MODIFICATION REQUEST:
Residential and Child Care Centre
Development
14-18 Boondah Road Warriewood
MP10_0177 MOD 10

Director-General's
Environmental Assessment Report
Section 75W of the
Environmental Planning and Assessment Act 1979

August 2012

NORTH ELEVATION
POOL and GYM

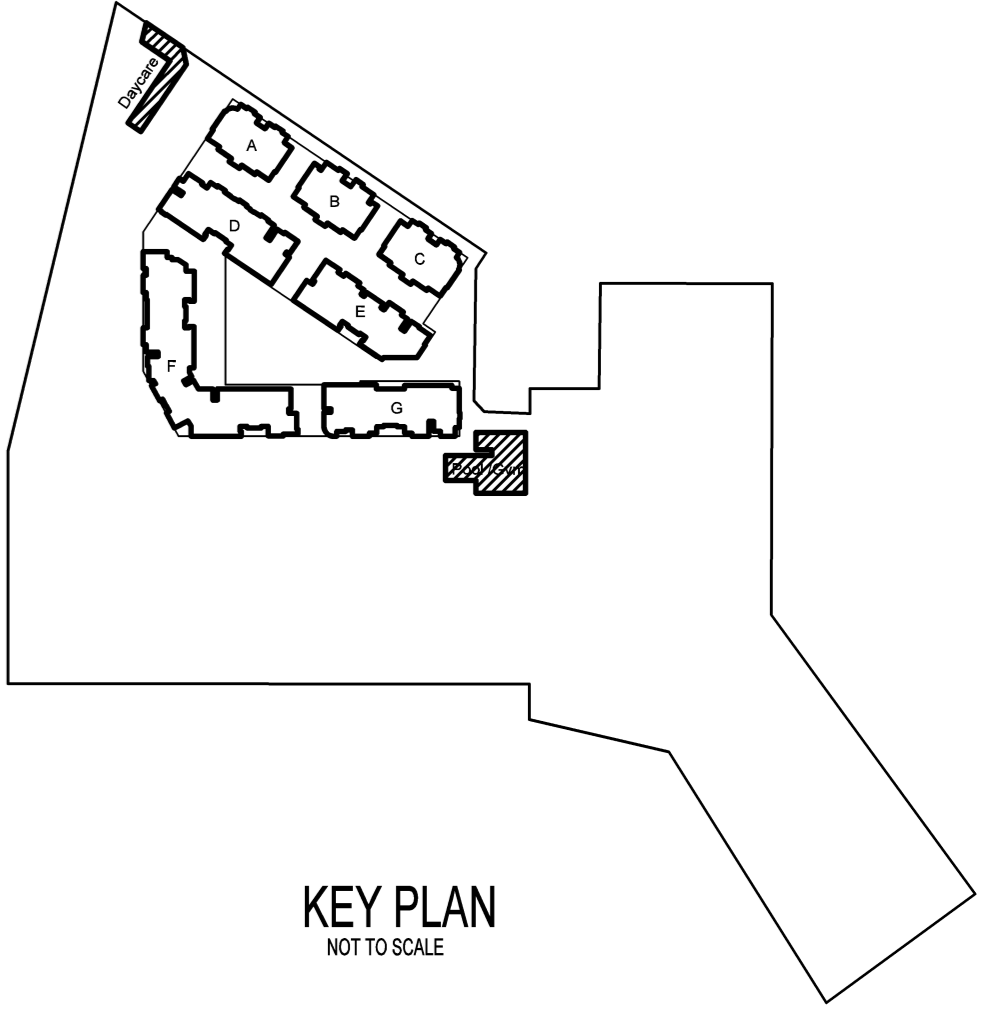
The pool building is proposed to be raised by 700mm so that the ground floor FFL is changed from RL 5.00 to RL 5.70. The level of the building is raised so that the floor level will be more consistent with the natural ground level. In other words, the proposal seeks to reduce the amount of building required to be built below ground level.

The design of the building including the overall building height and floor to ceiling height otherwise remains unchanged. As a result, there will be a marginal increase in the height of the building of 700mm. The Department raises no issue with the additional 700mm height of the single storey building as it would not pose a significant impact on the amenity of residents particularly given the building is only single storey in height and is surrounded by buildings of four to five storeys in height.

In this regard, the Department raises no issue with the proposed raising of the pool building.
